RE: SP-24-00014 MLH

RE: RU-24-00002 Carey

TO: All Staff
FROM: Public Works Plan Review Team
DATE: December 6, 2024
SUBJECT: RU-24-00002 Carey

SUBJECT: WDFW COMMENTS ON RU-24-00002 Carey

PROPOSED PROJECT AND RIPARIAN BUFFER MITIGATION

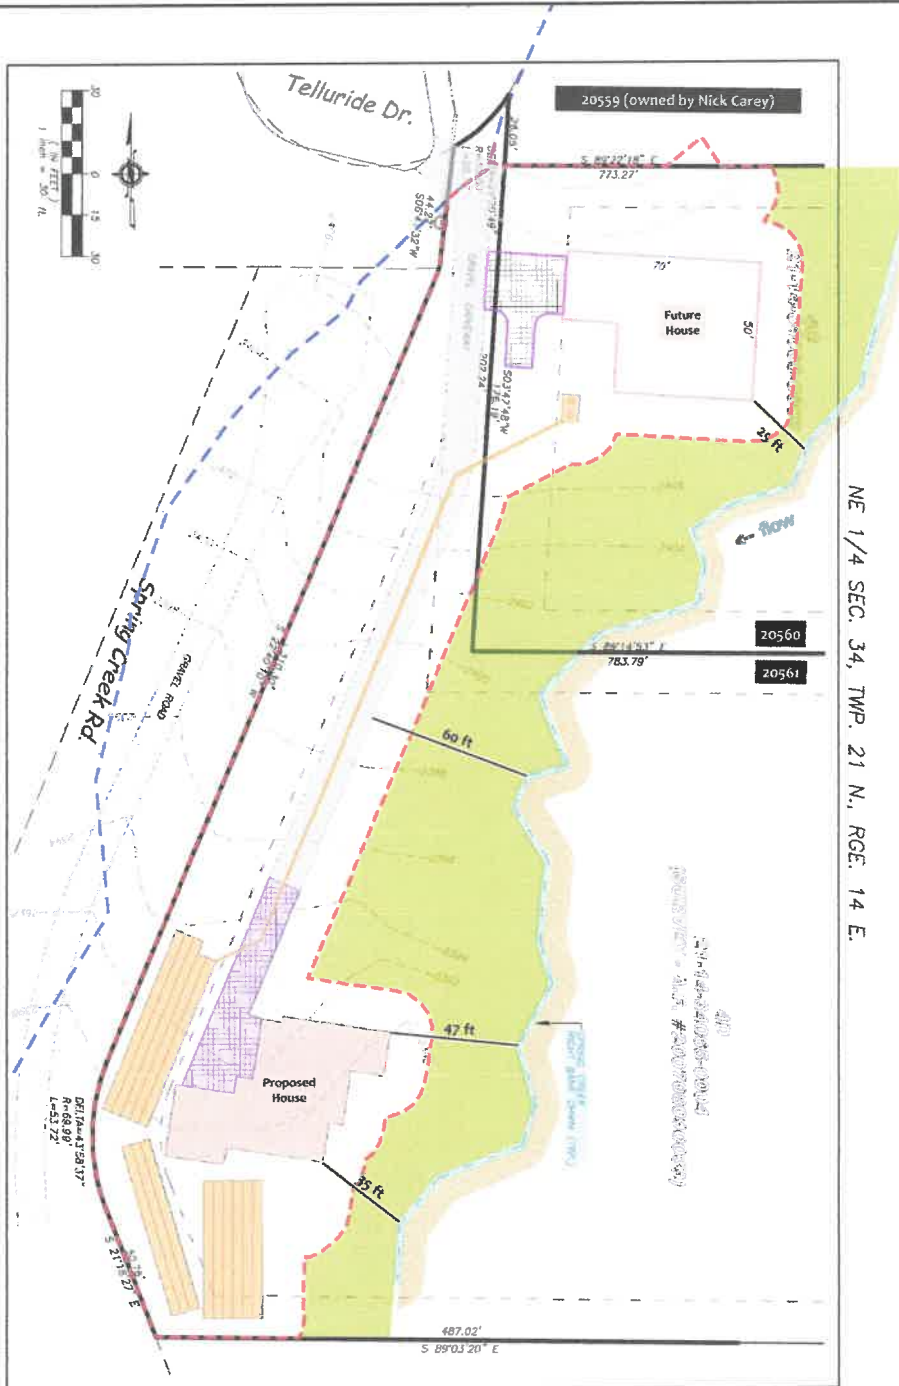
As discussed during the site visit, Spring Creek, a fish bearing tributary to Cle Elum Lake, bisects each parcel. The proposed home sites are located within the Spring Creek riparian management zone (RMZ, CAO 17A.04.030). To ensure no net loss, we recommend avoiding and minimizing impacts to the riparian buffer, particularly the mature conifer trees, as much as possible, by utilizing already disturbed areas and locations lacking mature overstory vegetation. Where impacts cannot be avoided, mitigation will be needed to offset the impacts to the riparian buffer.

We appreciate the Wetland and Stream Critical Areas Evaluation and Stream Buffer Mitigation Plan included with the application materials. However, we're unable to quantify the mitigation proposed to offset the 0.85 acre riparian impact. As currently proposed, the large wood additions are the only mitigation and thus its footprint should be equivalent to or greater than the loss of riparian habitat in order to achieve no net loss of functions and values. Please have the applicant quantify the amount of large wood (ex: number of trees) to be cleared during construction and placed into Spring Creek as mitigation, including the placement location(s) and how the wood will be positioned within the stream.

We recommend development of a detailed mitigation plan, to be reviewed and approved by WDFW prior to construction, as a condition of the reasonable use approval. The mitigation plan should quantify the proposed mitigation measures and demonstrate equivalent or greater

biological functions of FWHCAs consistent with Kittitas County's Critical Areas Ordinance (CAO 17A.04.070). If additional mitigation measures are needed to offset the 0.85 acre riparian impact, we are glad to further discuss options.
